Application No: Y/5/26/PL

Site Address: 2 Downview Road Yapton BN18 0HS

Description of works: Erection of terrace of 4 No town houses with gardens and parking spaces. This application is in CIL Zone 2 and is CIL Liable as new dwellings.

Thank you for your internet representation made on 6th April 2026 which has been recorded as an objection with the comments as follows:

2 Downview Road, Yapton : Proposed 4-unit 3-storey Terrace of 3-bedroom Dwellinghouses : PROPOSED SITE LAYOUT

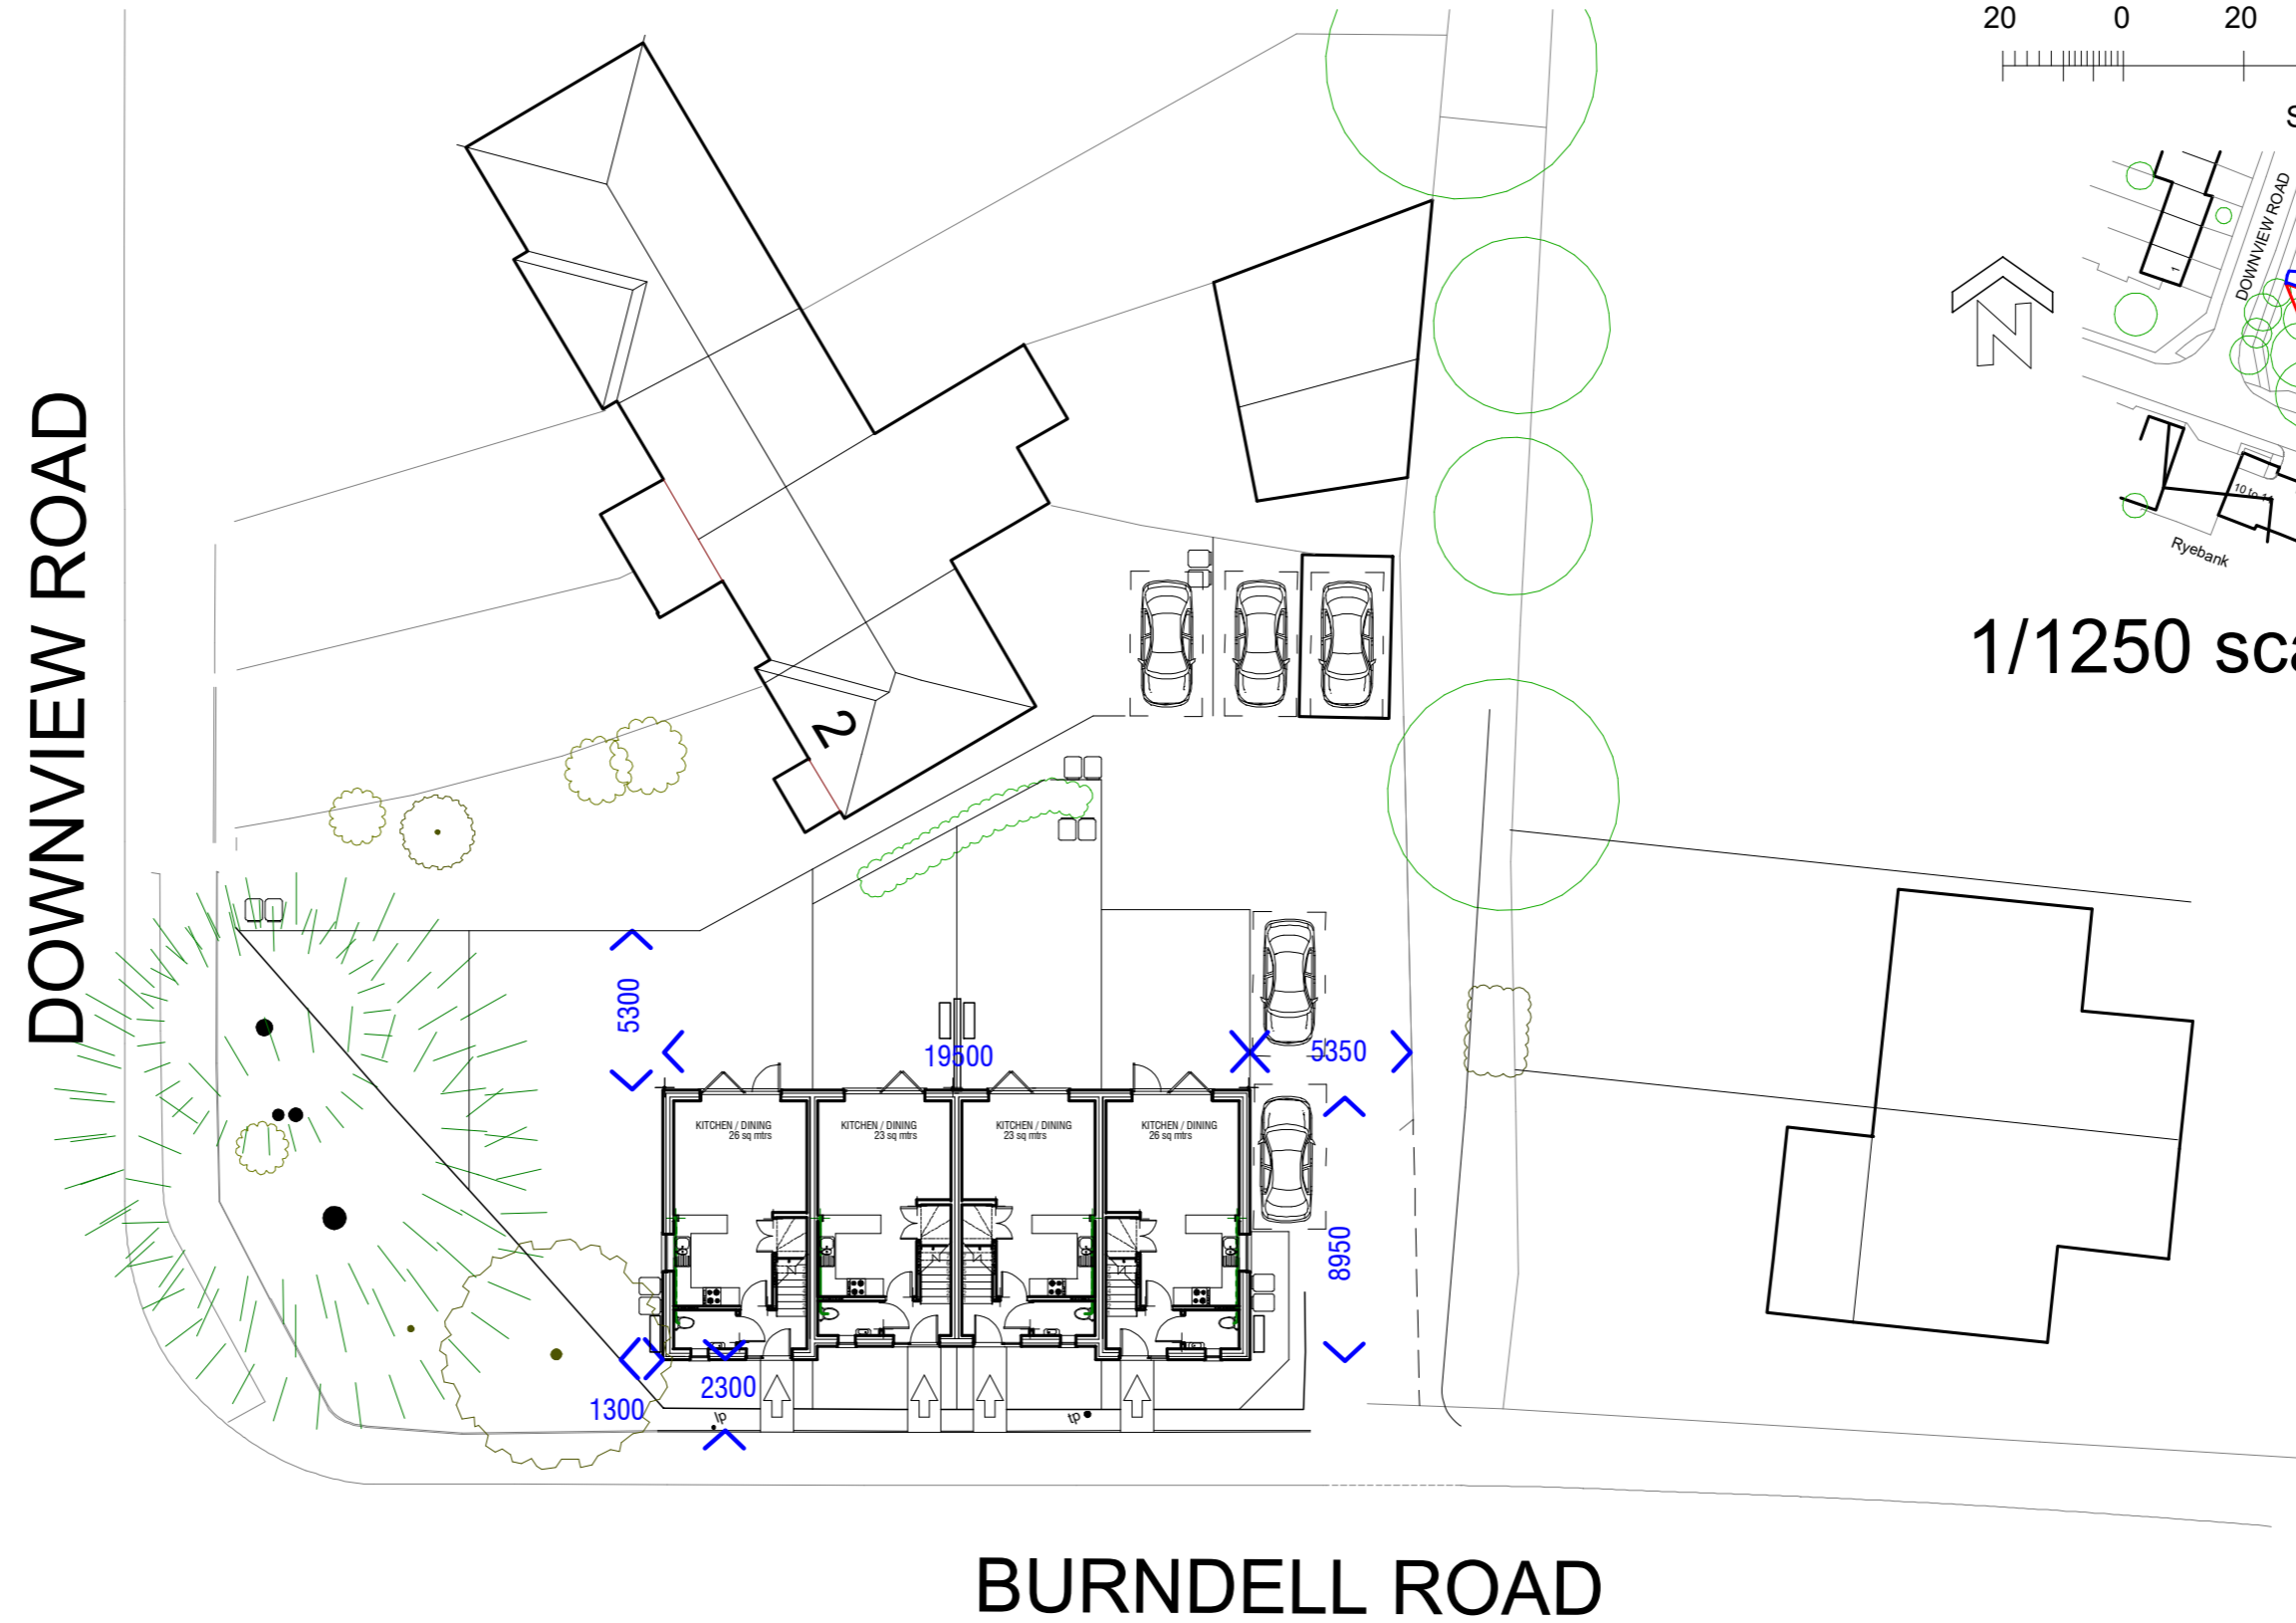
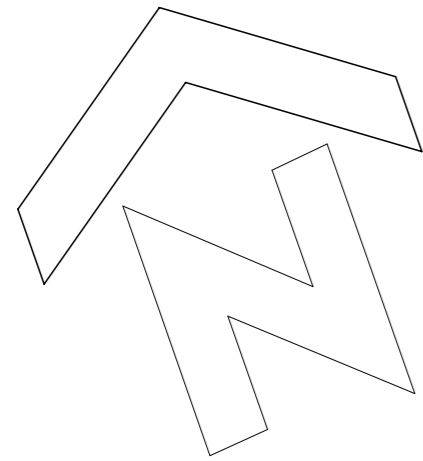
This proposed development is far too imposing for Burndell Road especially as the location is opposite a building that is also 3 storey. It would form a dark tunnel effect on the main road. The proposal would also overshadow nearby houses in Downview Road and Goodhew Close. The access to the parking area is directly from Burndell Road which adds a further access onto an already busy road. 4 houses on this site seems to be a vast overdevelopment.
